MARYSVILLE
PUBLIC WORKS

MEMORANDUM

TO: Chris Holland – Planning Manager
FROM: Jesse Hannahs, P.E. – Traffic Engineering Manager
DATE: August 29, 2023
SUBJECT: PA 23-010 – Ideal Industrial

I have reviewed the Ideal Industrial Shared Access with Undi for the proposed development of 14508/14821/14919 Smokey Point Blvd. & 3518/3528 150th PL NE and have the following comments:

SHARED DRIVE
STA: 191+00 to 197+23.65
Scale: 1"=4'

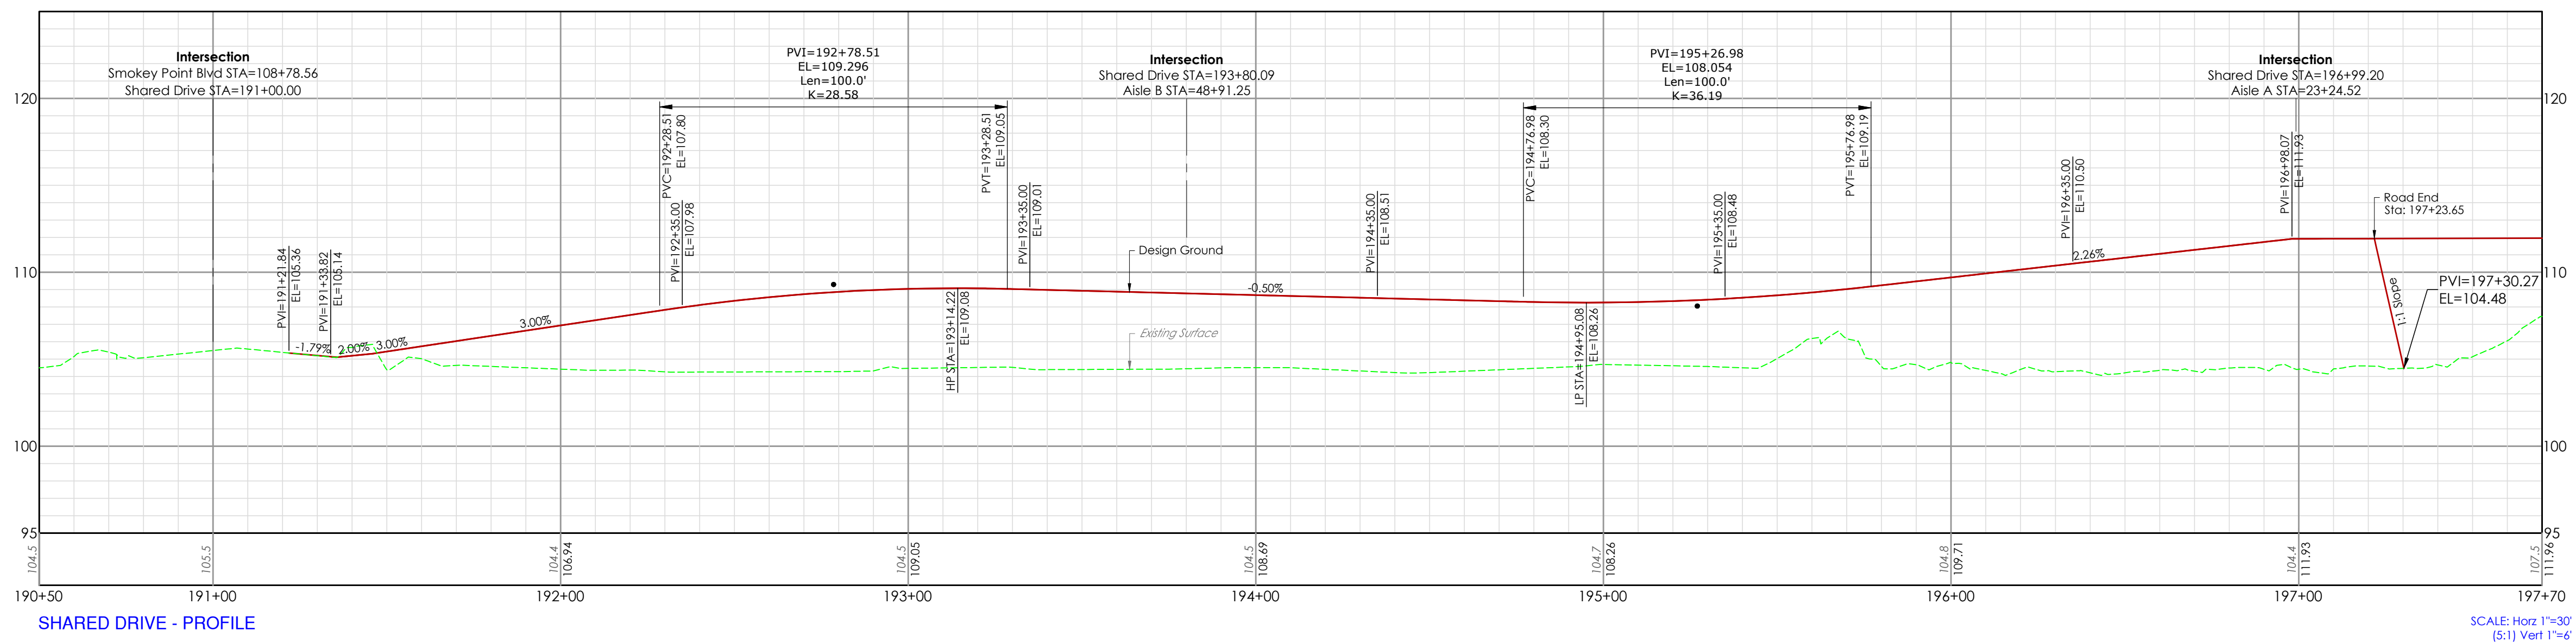
- 1) Per EDDS 3-301, access management standards shall apply.
 - a. Proposed southern shared access point aligns with northern unsignalized Marysville Fire District driveway with a span wire traffic signal installation.

- i. Access location is only 30-40' from the existing traffic signal.
 - ii. A deviation would not be supported by Public Works Traffic Division for a full access at subject location with a traffic signal as currently exists given the conflict between northbound Smokey Point Blvd. traffic and trucks exiting the Industrial Developments.

- iii. Public Works Traffic Division would potentially support a variance if the development were to provide for one of the following options:
 1. Modification of the existing traffic signal to include signalization of the proposed shared driveway within the signal layout.

- a. TIA would need to be performed to evaluate signal LOS assuming east/west split phasing with the east & west legs not aligned.
 - b. Existing span wire signal installation might need to be fully replaced and/or new signal poles with mast arms be installed to accommodate new signal heads necessary.

- c. Channelization modification to Smokey Point Blvd. would be required.
 - d. Signal installation/modification would be required to meet current MUTCD and ADA guidelines.

- Or
 2. The existing traffic signal would need to be reduced to an Emergency Fire Signal only by:

- a. Reconfiguring span wire signal heads to provide for fire signal operations only.
- b. Relocating the existing pedestrian crosswalk contained within the traffic signal operations to the north or south with the installation of a marked two-stage offset mid-block crosswalk with RRFB systems.
 - i. Fully built-out Pedestrian Median Refuge Island will be required with pedestrians having a 2-stage RRFB system with a non-direct through pedestrian path to encourage viewing of oncoming traffic. (See example at Grove ST & Bayview Trail west of 81st DR NE)
- c. CT Bus Stops on both east and west side of Smokey Point Blvd. will need to be relocated to be near relocated crosswalk with RRFB.
- d. Location of proposed pedestrian crosswalk with RRFB shall be located to provide for the least negative impact to utilization of the existing two-way left turn lane.
